**Consultation Response from KC,
Highways Development Management**

2025/90527 Land adj, 67, Elm Tree Close, Norristhorpe, Liversedge, WF15 7BU

**Change of use of land to domestic garden, formation of access and hard surfacing and
erection of 2.0m high fencing, greenhouse and gazebo**

Date Responded: 8-4-2025.

CLIENT:	MR J KAYE
PROJECT:	LAND AT LODGE LANE LIVERSEDGE WF15 7FG
DRAWING TITLE:	AS PROPOSED
PROJECT REF:	2025-060
DRAWING NO:	200
REVISION:	-
SCALE:	AS SHOWN @ A1
DATE:	FEB 2025

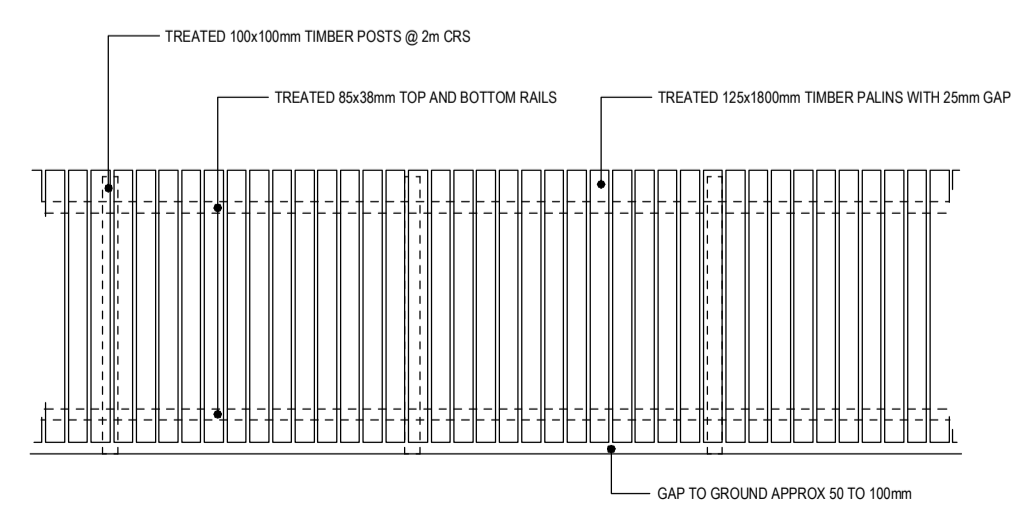
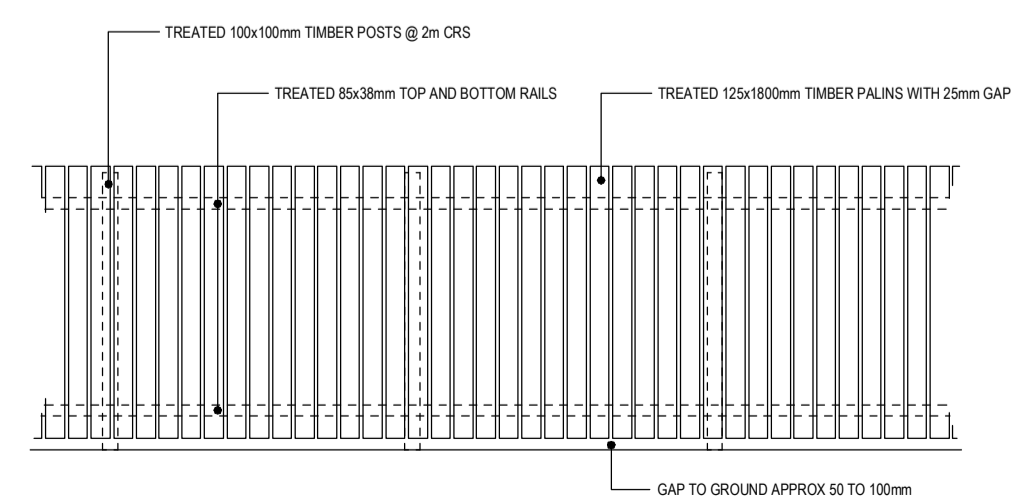
1, The 2.0m high fence to the frontage will obstruct visibility for vehicles using the proposed access onto Lodge Lane.

2, The fence will also obstruct visibility for pedestrians exiting the public footpath adjacent to the boundary (SPE/145/20) and the Elm Tree Close footway where it meets Lodge Lane.

For these reasons H D M would recommend that the fence is reduced in height to no more than 0.9m above the level of the adjacent highway and that suitable visibility and pedestrian/vehicle intervisibility is shown to be provided.
